Please ask for: Ms Iqraa Malik
Email: iqraa.malik@terraquest.co.uk
Telephone: 0121 234 1390
Our Ref: M/38/22/HH
Your Ref:
Date: 11th April 2022

Application for Planning Permission for Works or Extension to a Dwelling

Development: Single storey ground floor extension to existing residential property
Location: 1 West Drive Middleton-On-Sea PO22 7TS

BLOCK PLAN 1:500

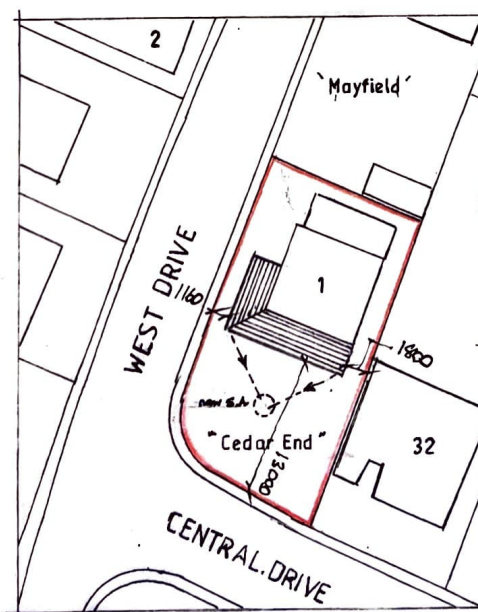
Dimensions: You are required to include dimensions on the block plan from the proposed site to all site boundaries.

LOCATION PLAN 1:1250

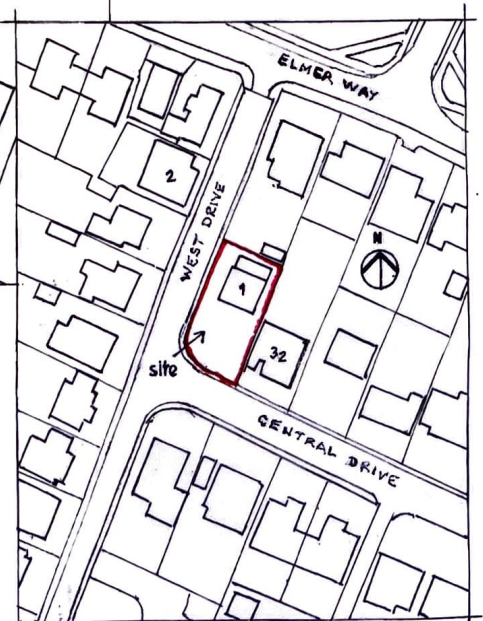
Location Plan: You are required to include a red outline on the location plan around the proposed site. Please amend.
